Commercial Team Comment

Pollution Team Comment

APPLICATION NO: EP/88/08/
Registered: 29-MAY-08
Site Address: 27 Sea Road East Preston
Grid Reference: 507154-102280
Category: Plan Applicat'n
Description of Works: Change of use from Bank to Indian Tandoori Restaurant (A3)

Proposed Ground Floor Plan

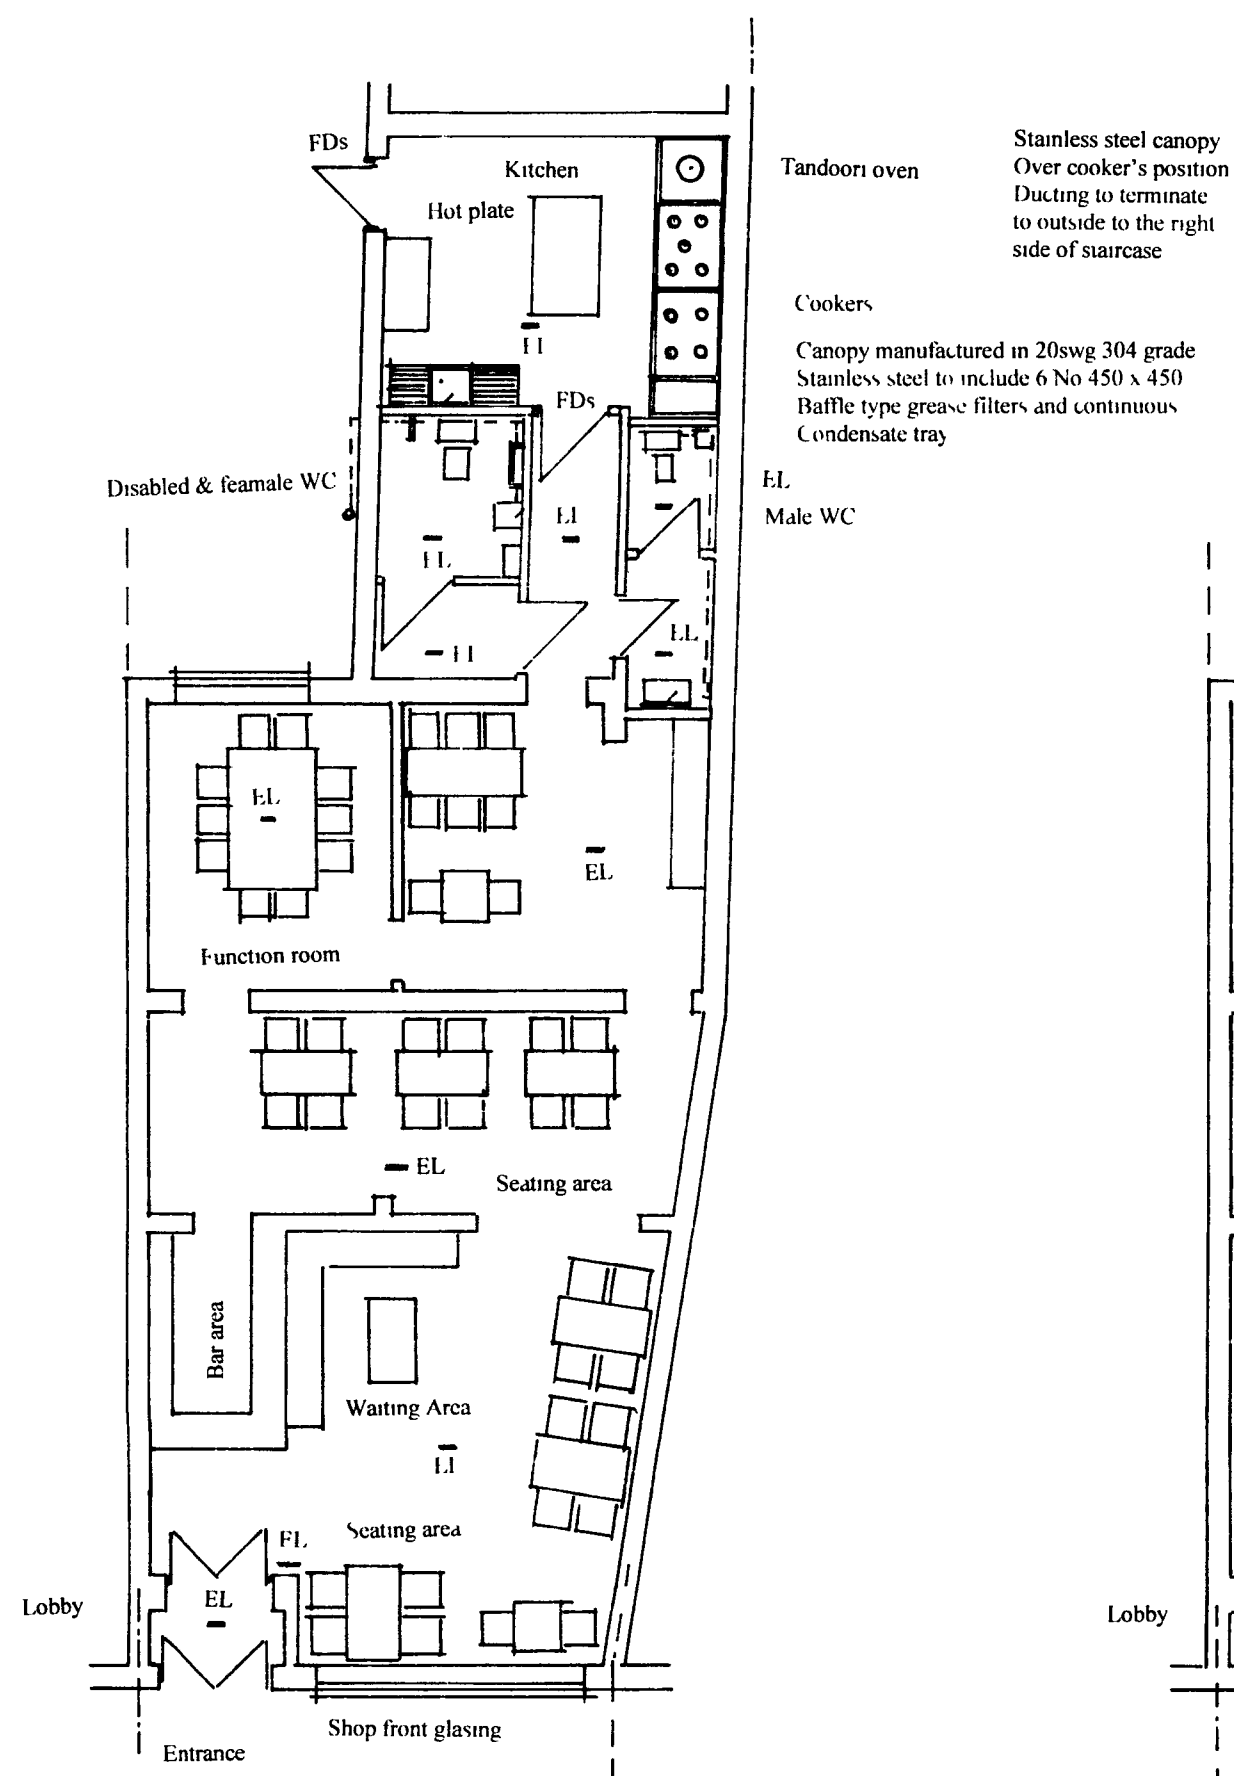
Having examined the plans and supporting application, the proposed kitchen is undersized for a proposed seating area of up to 44 covers. The dimensions of 15 m sq. is in my opinion wholly inadequate for the preparation of high risk foods and workplace for up to 4 persons. The applicant has not provided a suitable area for the storage of dry food which will be significant for this no. of covers. The layout indicates a shortage of wash facilities, probably due to inadequate space, the storage of pots, pans and necessary refrigeration equipment will place further demands on the limited dimensions of the kitchen area. The discharge of strong spicy odours at first floor level will require a high level of odour control, the application does not provide adequate information on how this will be achieved in order to prevent the potential of nuisance to nearby residents.
